ROAD VACATION – EXHIBIT B

LOGGER ROAD AND A PORTION OF WOODLAND ROAD, TIMBER RIDGE SUBDIVISION FILING NO. 2
EL PASO COUNTY, COLORADO

SCALE: 1" = 100'
JOB NO.: 17083
JULY 31, 2018

ROAD VACATION - EXHIBIT B

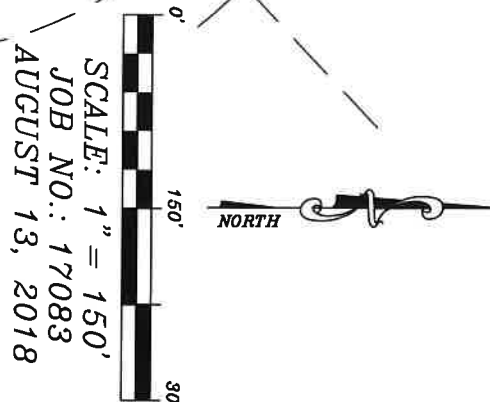
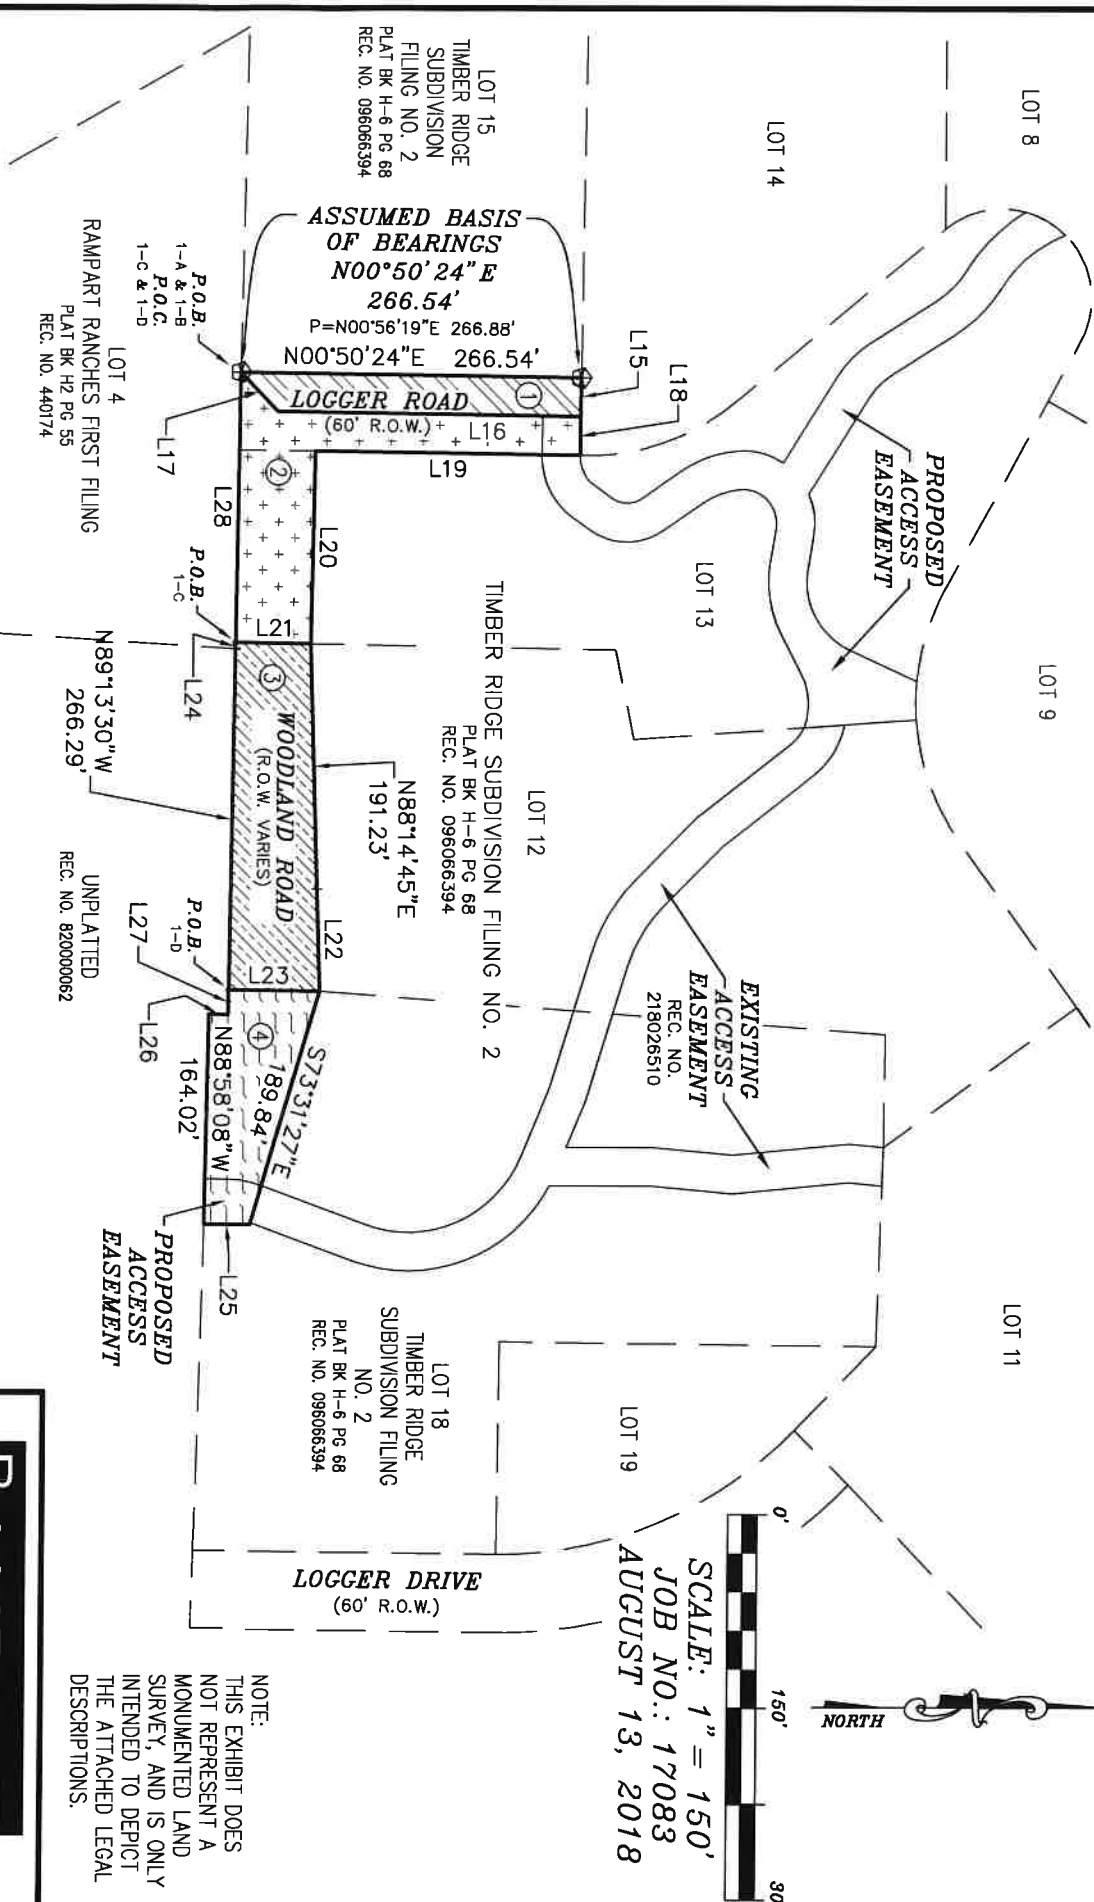
Add the legal descriptions to be vacated to the page or create a second page. (Only one legal was uploaded in word format. Make sure you upload all 4 legals as one word document under the legal description slot or it will overwrite the previous upload.)

Since ROW will not go to the property owner to the south this triangle can go to the lot to the west.

as recorded at Reception NOs. _____ (fill this in- easements have to be in place to vacate)
